# CSV ARCHITECTS

August 24, 2022

Re: Application no.: A22-003792 – 78 Rosemount Avenue

In response to your comments dated July 4th, 2022, I am providing the following information:

EXTERIOR ELEVATIONS

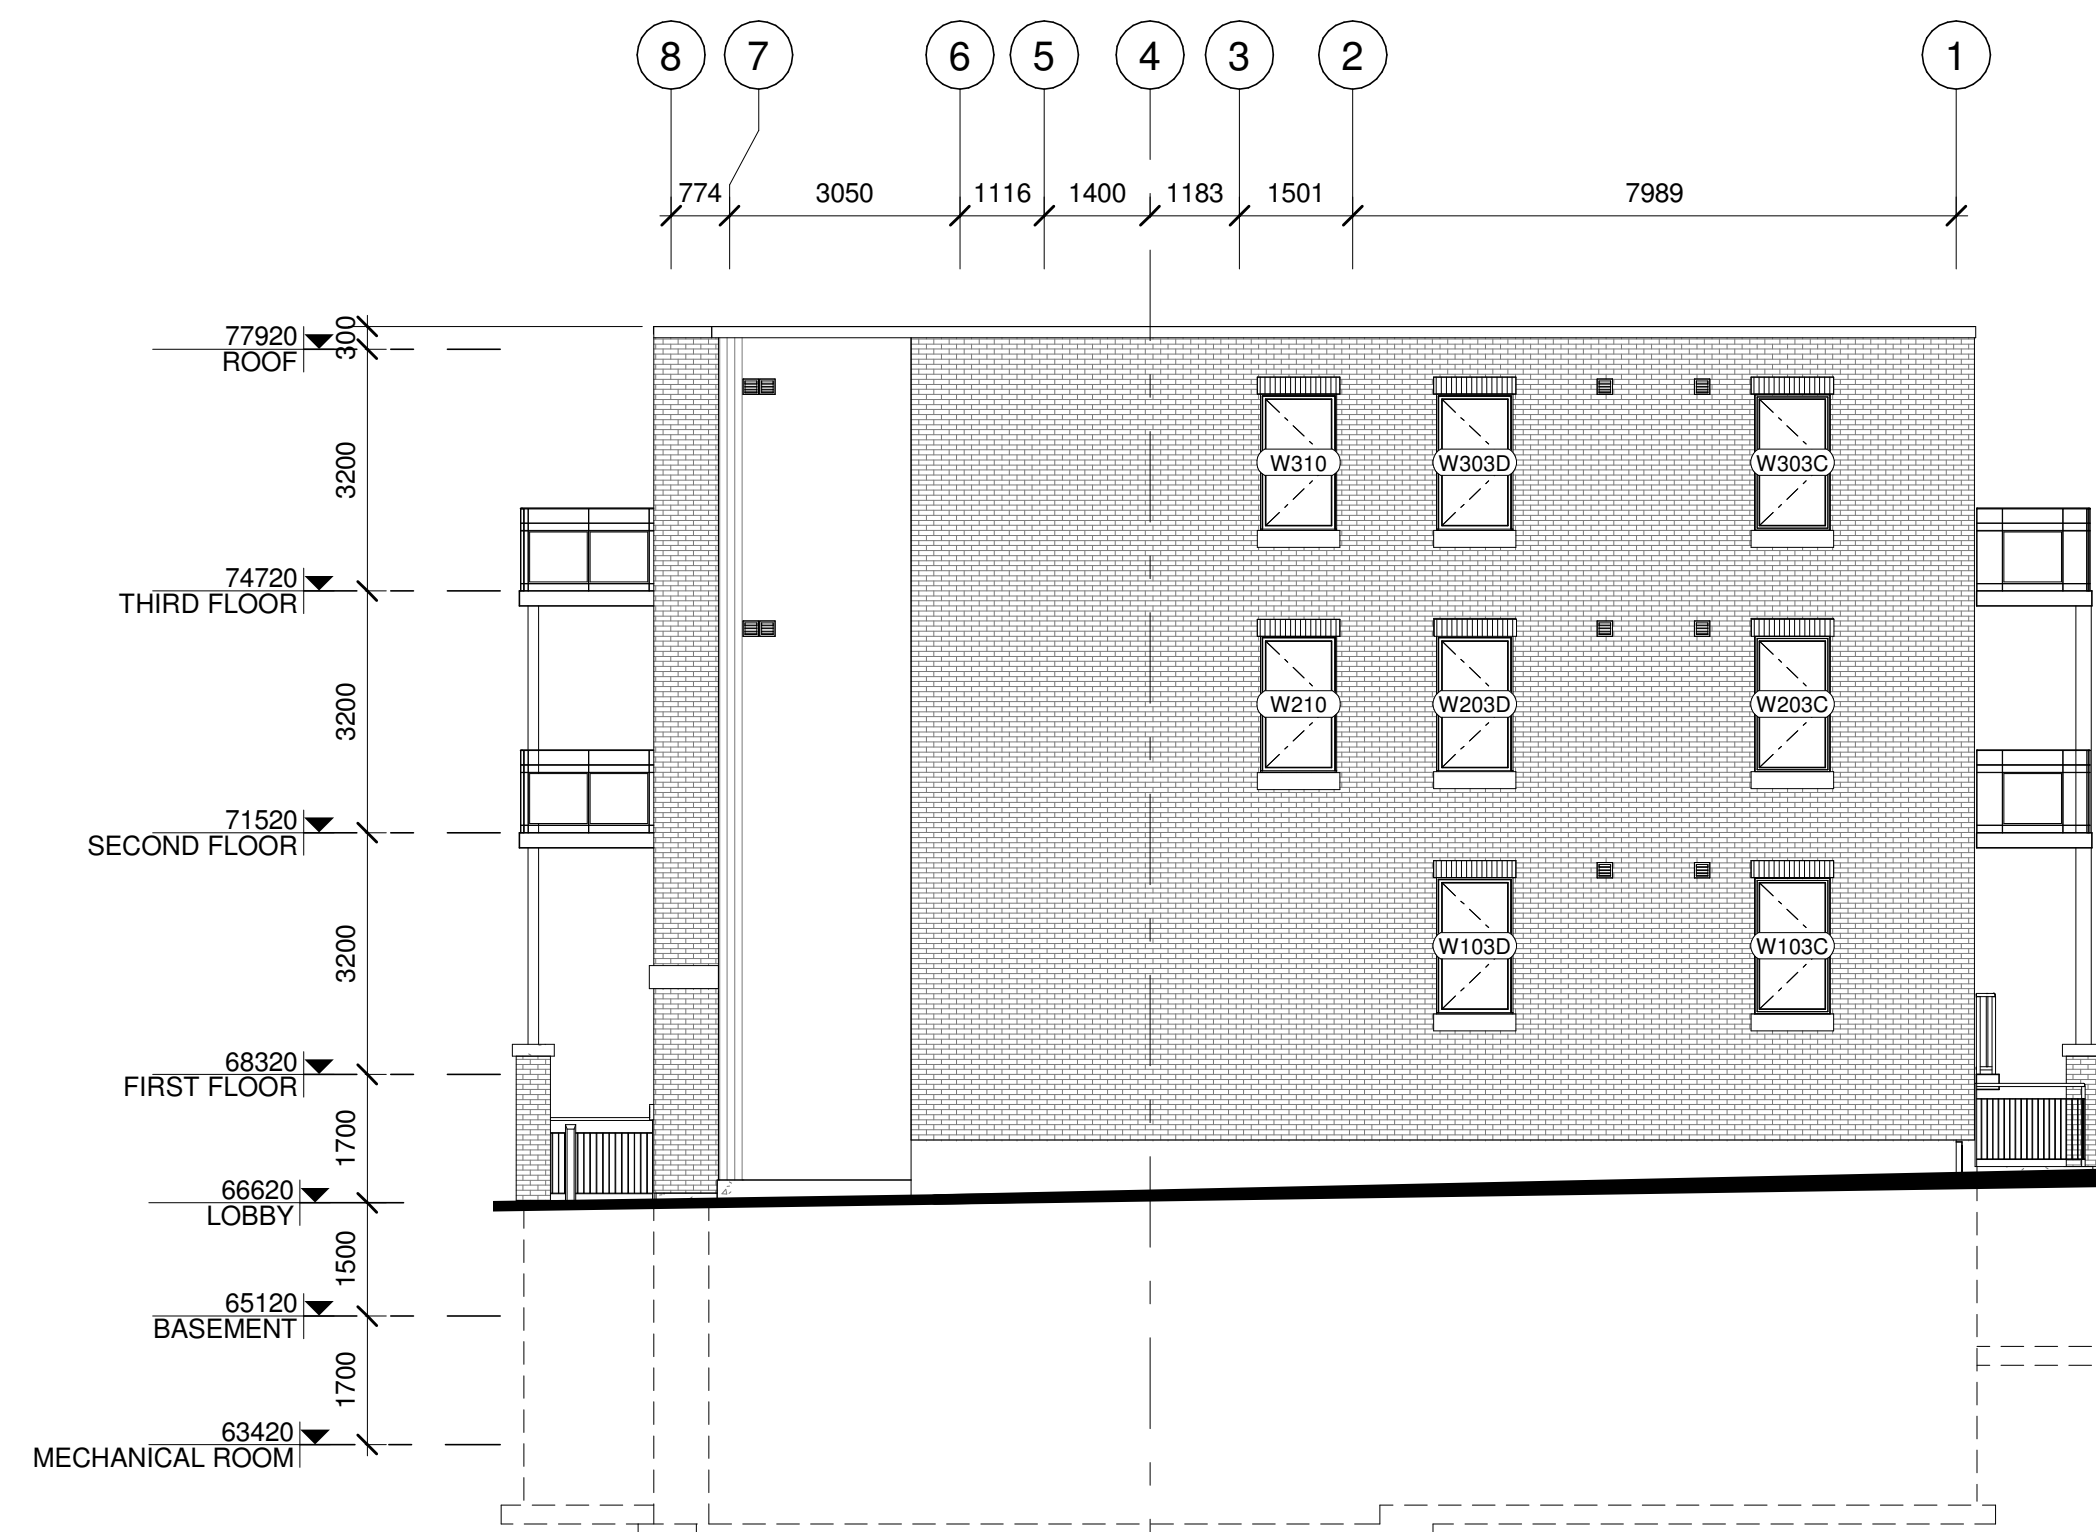
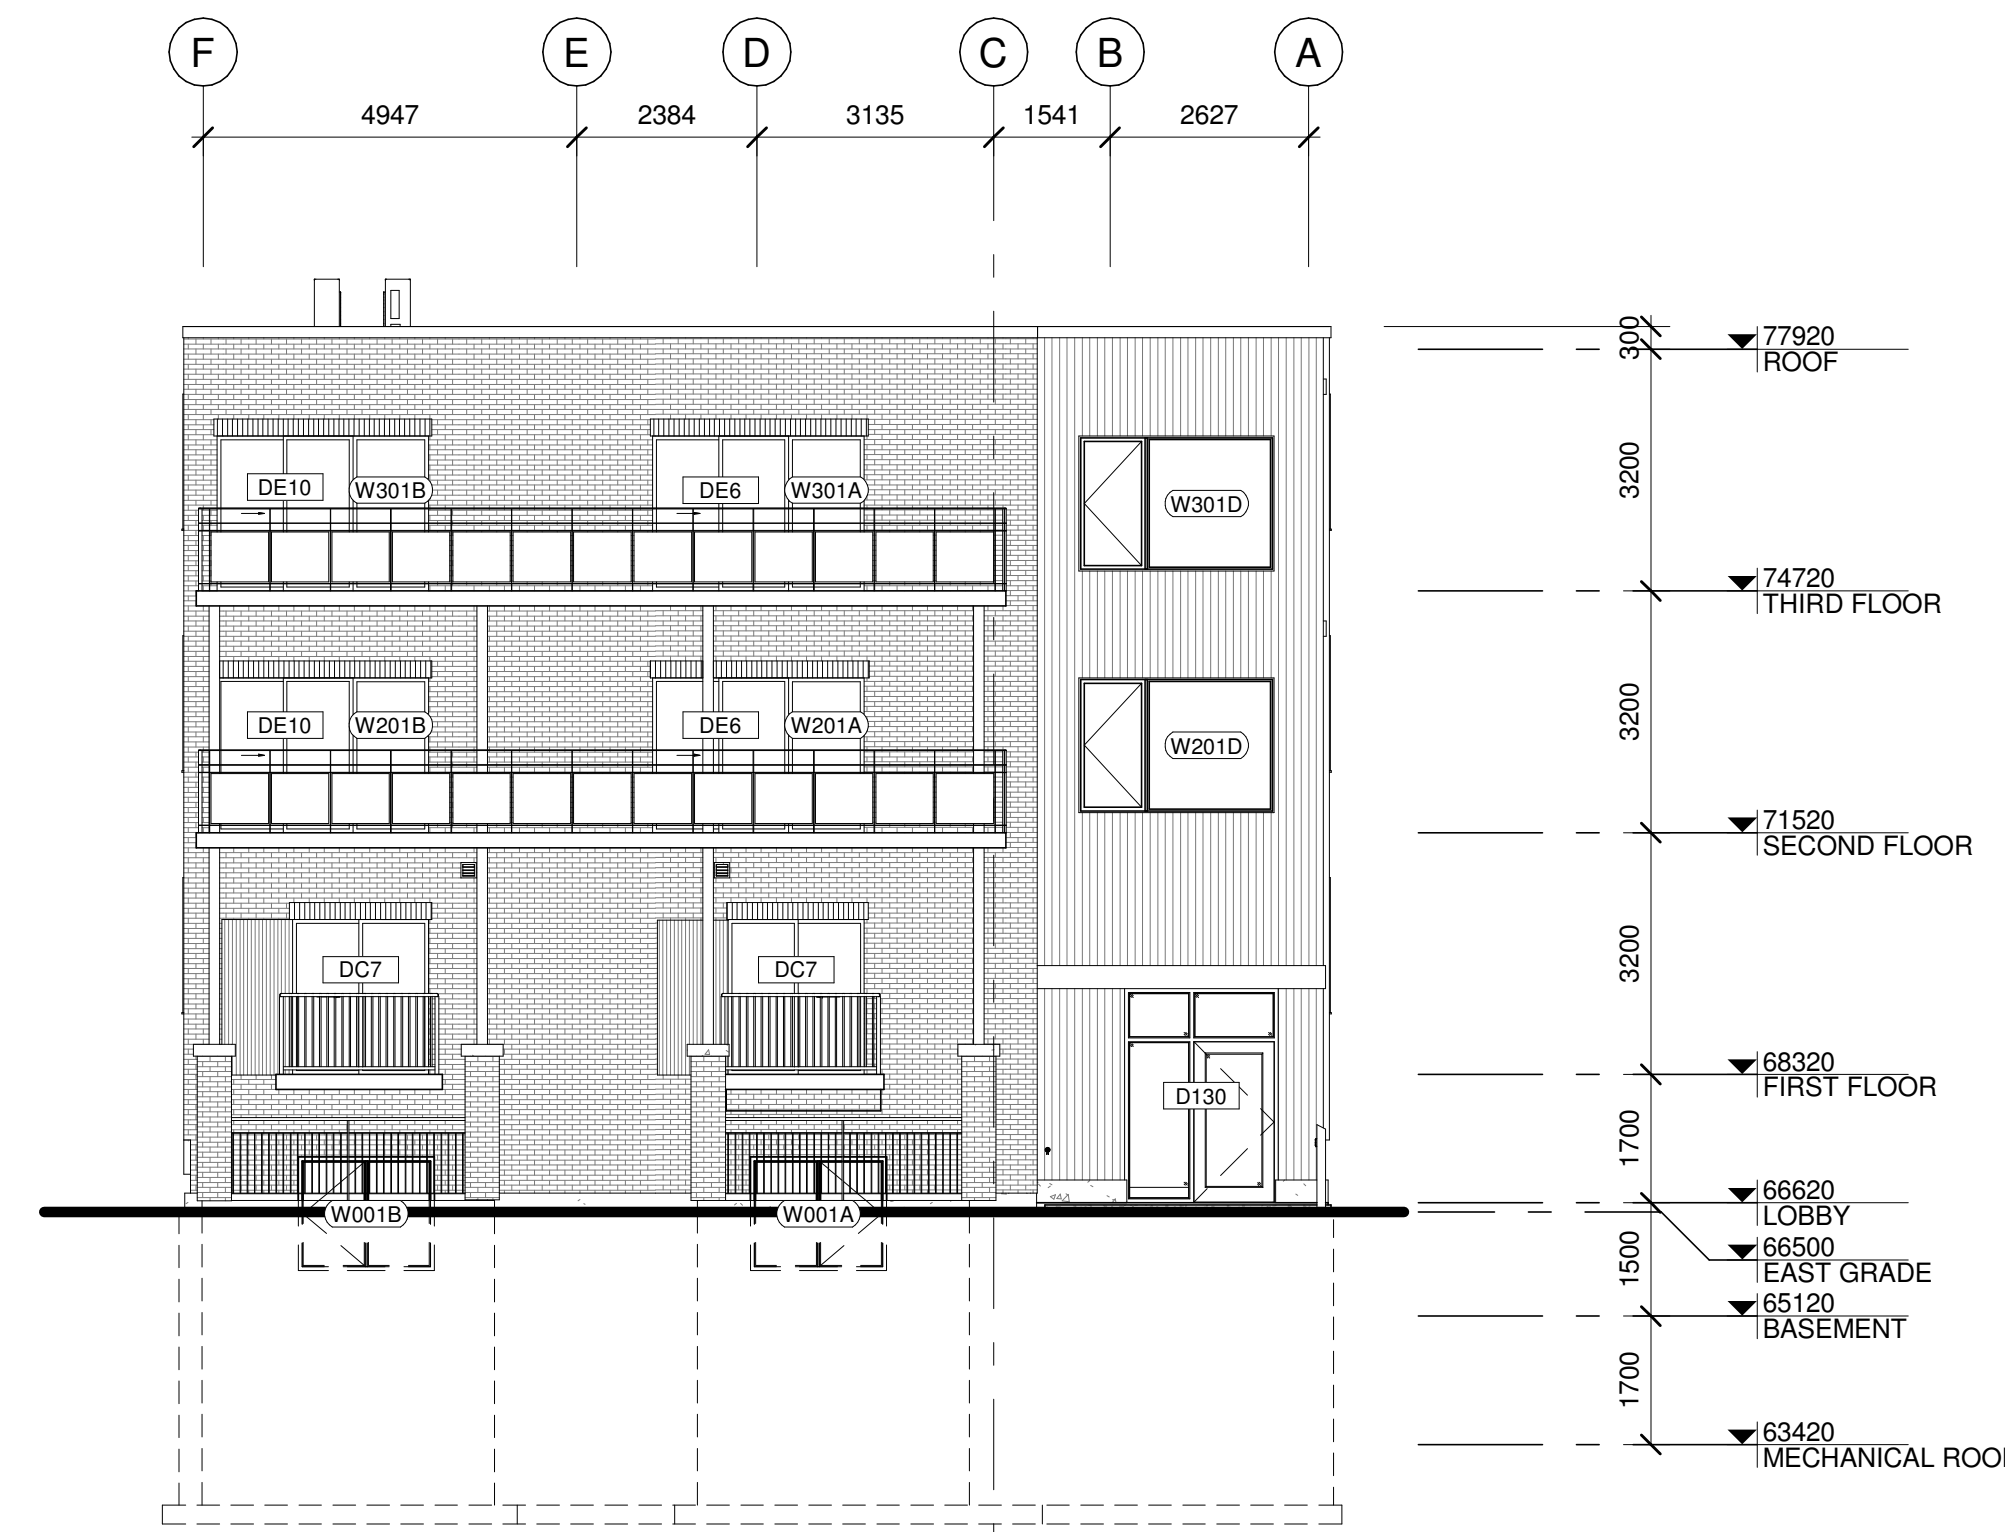
1. The Queensway approval application has been submitted, Aug. 11, 2022, Application Number: 2022-00004071, assigned to Brian Hickey, Ministry of Transportation. See attached.
2. Attached please find the topographic survey. The dimension is taken to the face of the building. There are recesses on the ground floor, however, the majority of the façade is flush at 3.063m. Please see image below:

$66.58 + 66.85 + 66.95 + 66.54 = 266.92 / 4 = 66.73$ . We are adjusting the building height by 19mm to accommodate. Please see the revised elevation drawings for where this mark is located.

4. Please see the revised elevation drawings attached indicating the min. 25% window amount.
